KIRKLEES METROPOLITAN COUNCIL INVESTMENT & REGENERATION SERVICE

DELEGATED DECISION TO DETERMINE PLANNING APPLICATIONS

Reference No:	2025/62/90644/W
Site Address:	Mount View, Sheffield Road, New Mill, Holmfirth, HD9 7HA
Description:	Demolition of existing conservatory and erection of single storey rear extension, erection of replacement garage, porch to front elevation, and associated external alterations
Recommending Officer:	Molly Storer

DECISION – CONDITIONAL FULL PERMISSION

HOUSE REAR ELEVATION

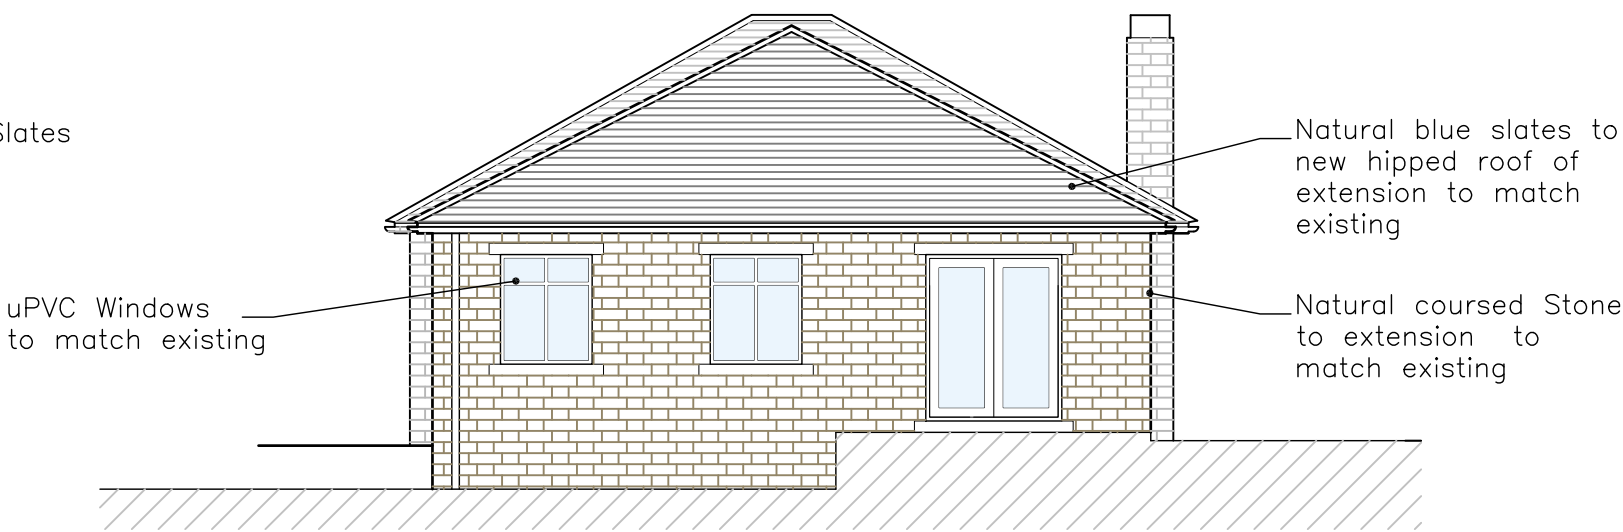
- 3.575m projection from the rear elevation
- 9.5m width
- 2.75m to eaves
- 5.2m overall height
- Hipped roof design with matching materials.

- 1.85m projection from the front elevation.
- 3.15m width
- 2.8m height to the eaves
- 3.9m overall height
- Gable roof design

With regards to the proposal the rear extension will exceed 4m in height however, due to the property being a bungalow and the extension being set down from the original roof ridge and set in from either side elevation in this instance this is considered acceptable. The house is detached and the projection will be less than 4m and there will be more than a 1m gap to each side boundary. Therefore, although the extension is not wholly SPD compliant on balance this is considered acceptable.

The porch extension would be small in terms of size and scale and would be well set back from the highway by around 14m. It would have a limited overall height of 3.85m and would have a gable roof design to match the garage. It would be set well away from neighbouring properties and is therefore considered acceptable.

Whilst the width of the porch is of a size which may not be visually acceptable in other circumstances, in this case weight is afforded the space which would remain in relation to neighbouring properties and also the fact the porch would be of a similar size, scale and design as that which has been undertaken to the immediate neighbouring properties.

Whilst there would be an additional window in the elevation facing this property, there would remain a separation distance of 3m to the boundary wall and 8.5m to the conservatory at Monrita. It is noted that this would cause some level of overlooking to this conservatory however it is not considered to be significantly higher than current levels of overlooking which could take place from the

conservatory at Mount View. There would be no windows within the side elevation of the garage or the porch (only a single door with a separation distance of 6m to the boundary mitigating any impacts). The garage would be screened by the double garage at this property and would not be largely visible from the rear garden of Monrita. The decking would be accessed via steps from Wildspur Grove and would be used to access the rear elevation. This decking would be on the same level as the rear elevation which is the existing situation. Therefore, although this would be coming further forward it is not considered to have any significantly additional impact.
